Accessibility Review Report – DA Review

Project Title: **Northside West Stage 2
23-27 Lytton Street, Wentworthville**

Date: **3 November 2021**

Report Version: **20466_ADR_DA_v1.1**

OVERALL SITE PLAN - LOWER GROUND
Scale: 1:200
903 As @A1 IK VM
Drawing No. indicated Rec
DA0100 3

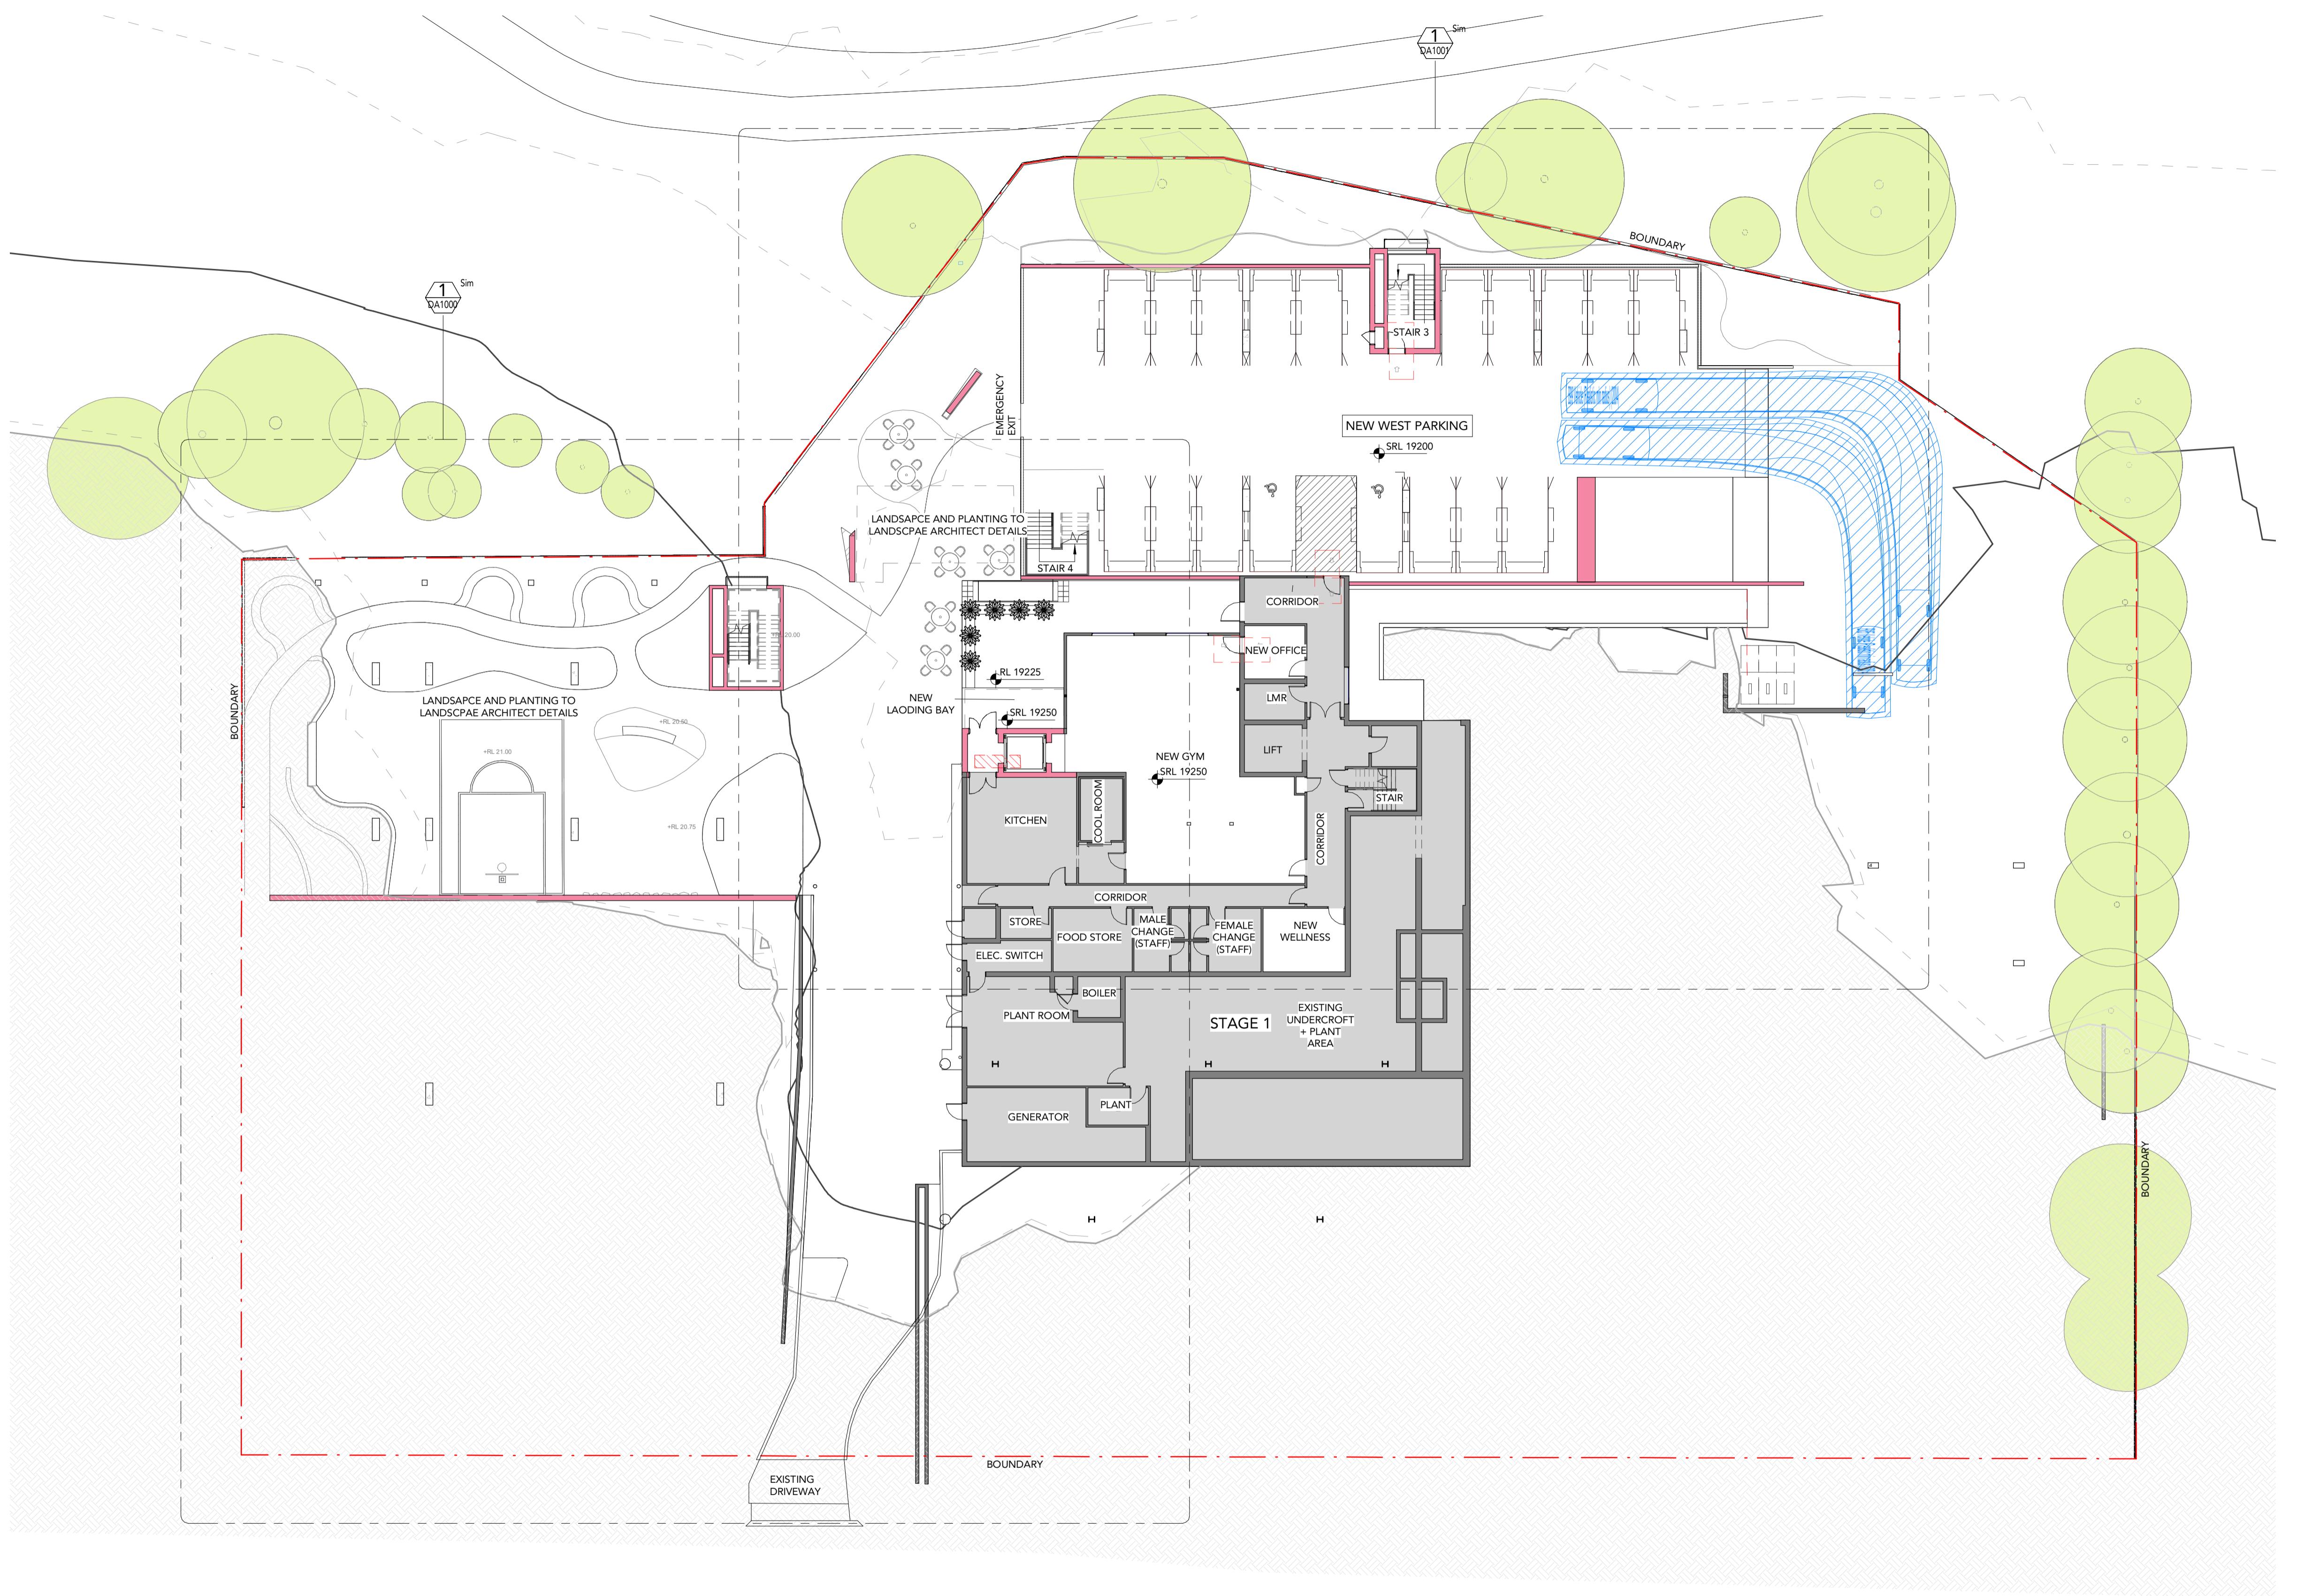
DtS Provision	Comment(s)/Recommendation(s)	Status
In a building required to be accessible every ramp and stairway, except for ramps and stairways in areas exempted by D3.4, must comply with –		
<ul style="list-style-type: none"> • for a ramp, except a fire-isolated ramp, clause 10 of AS 1428.1; and 	<p>All non-fire-isolated ramps are required to comply with AS1428.1-2009.</p> <p>A single ramp is proposed on the Lower Ground Floor behind Stair 4.</p>	CD

<p>Drawings are to indicate the proposed gradient of the subject ramp.</p> <p>Compliance is otherwise readily achievable.</p>	
<ul style="list-style-type: none"> for a stairway, except a fire-isolated stairway, clause 11 of AS 1428.1; and 	<p>All non-fire-isolated stairways are required to comply with AS1428.1-2009.</p> <p>Unless new stairways are fully fire-isolated stairways all new stairways are to be designed to accord with AS1428.1-2009.</p> <p>Ensure stairways are setback from internal corners and the like to allow for the installation of handrail extensions.</p> <p>Compliance is otherwise readily achievable.</p>	DD
<ul style="list-style-type: none"> for a fire-isolated stairway, clause 11.1(f) and (g) of AS 1428.1; and 	<p>Confirm which stairways are proposed to be fully fire-isolated.</p>	DD
<p>Accessways must have—</p> <ul style="list-style-type: none"> passing spaces complying with AS 1428.1 at maximum 20 m intervals where a direct line of sight is not available turning spaces complying with AS 1428.1 at 20m intervals or within 2m of the termination of an accessway. 	<p>Compliance is readily achievable corridor are generally provided with 1900mm clear widths.</p>	CoC

Drawings are to indicate allocation of ambulant cubicle within Ground Floor toilet bank.

Provide allocation of ambulant cubicles within the Ground Floor bank of toilets.
